From: Daniel Vick
Sent: 08 October 2019 17:44
To: chris sprules [REDACTED]
Subject: RE: AL/32/19/OUT

Sustainable transport

The application lacks sufficient detail on how it will support Sustainable transport. NPPF Sec9, WSCC Cycling and Walking strategy

Cycling Route Map

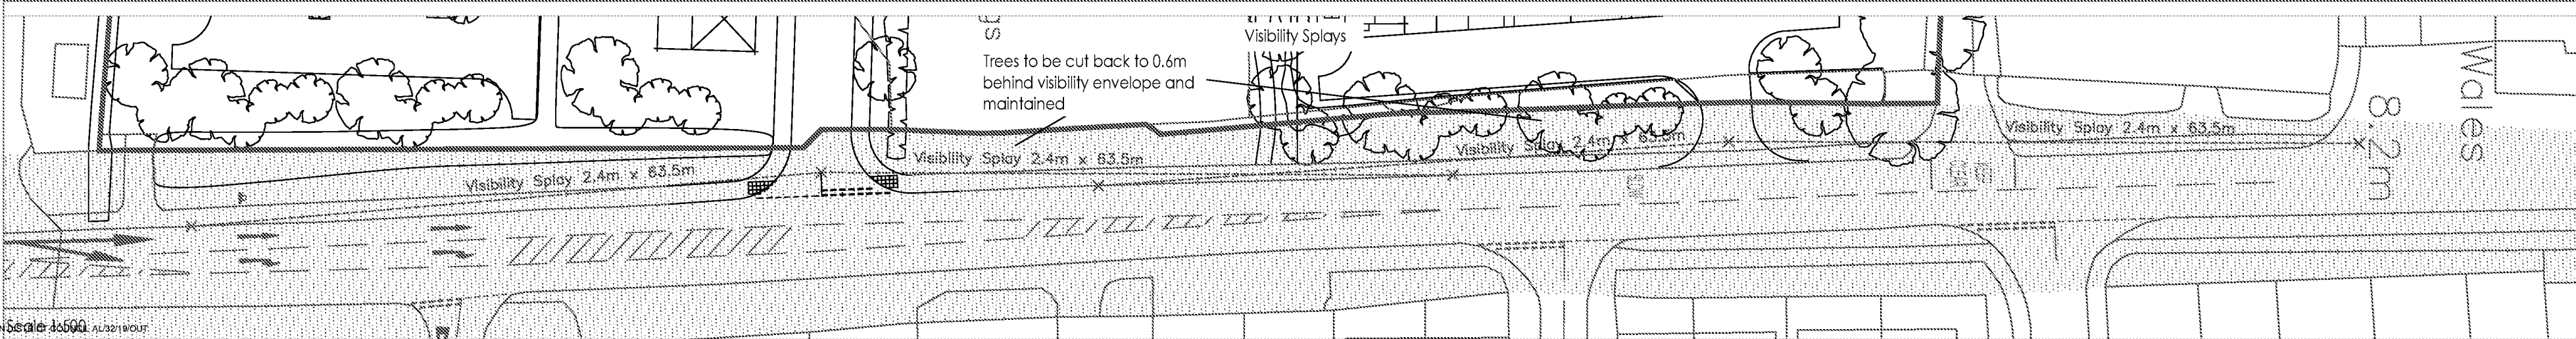
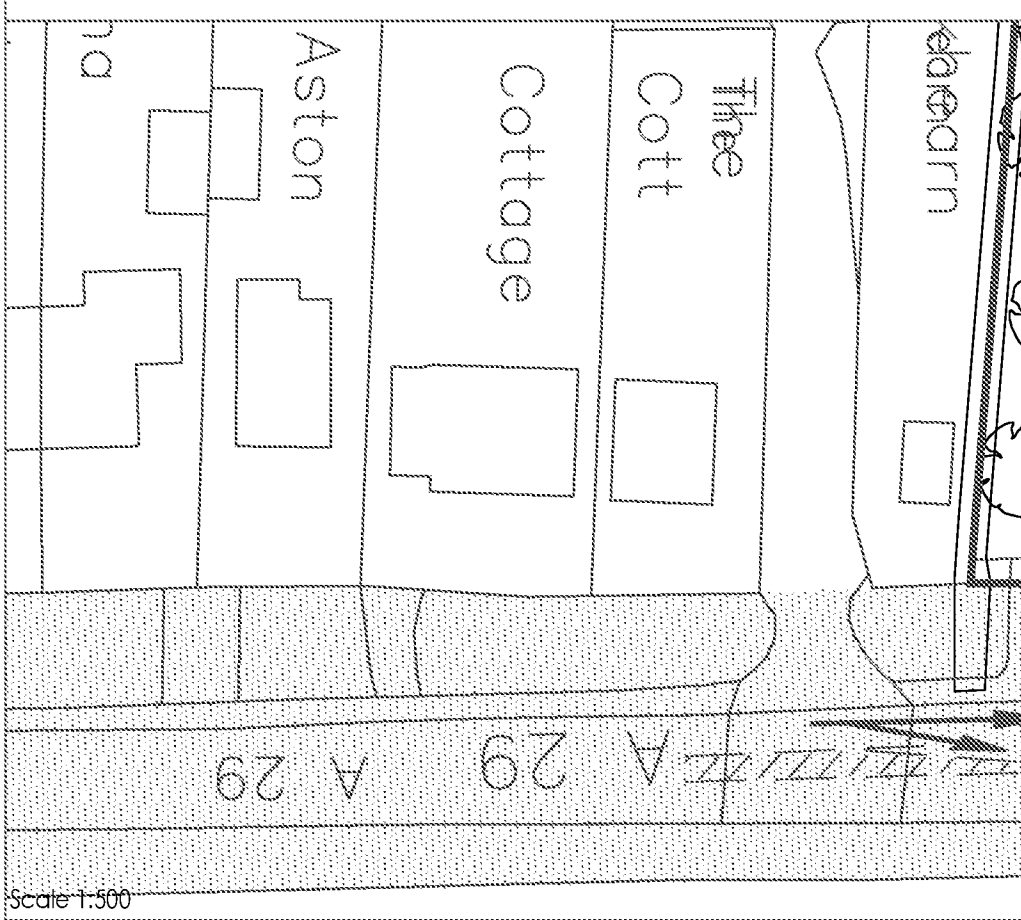
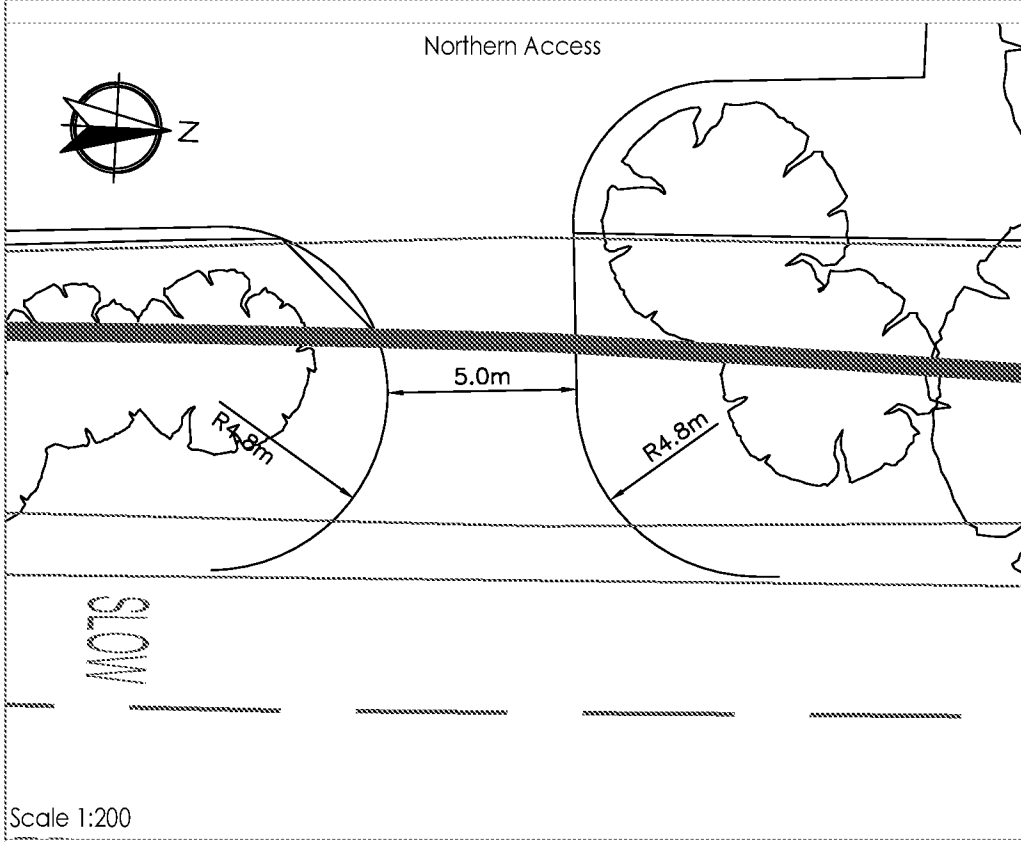
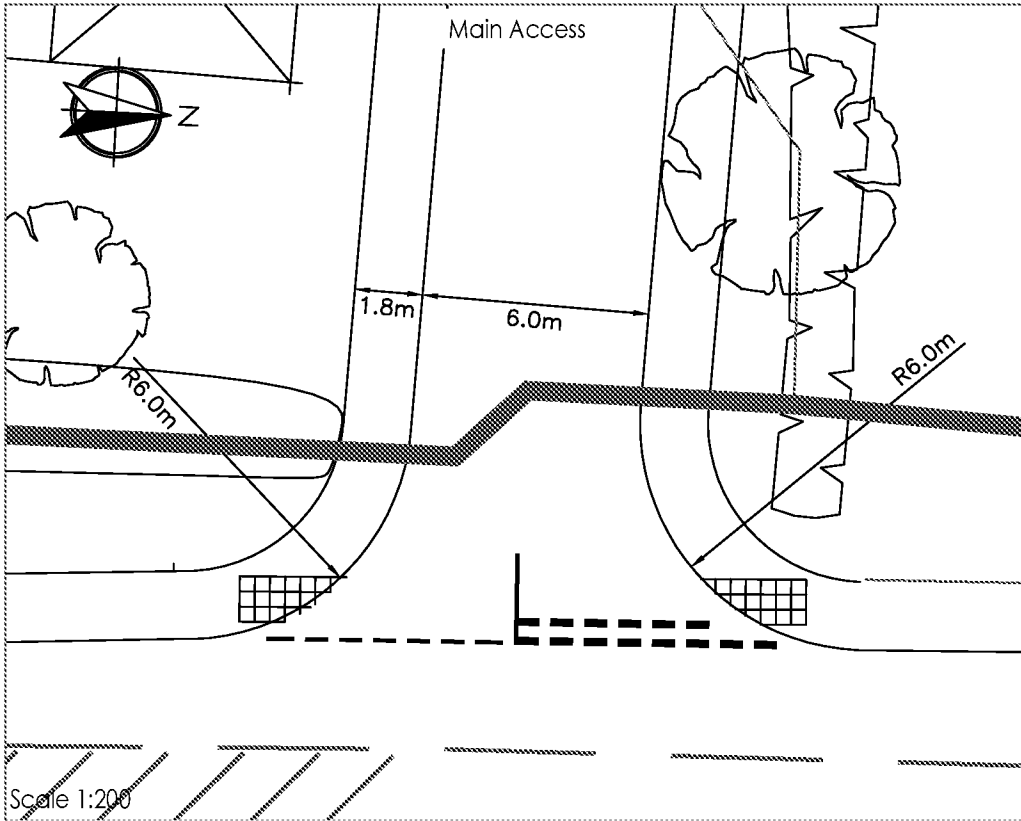
Cycle routes and paths across this site and interconnecting routes need to be planned. Routes need to allow residents access to Bognor, Chichester, Schools and shops and should include links to local cycle networks and the National Cycle network
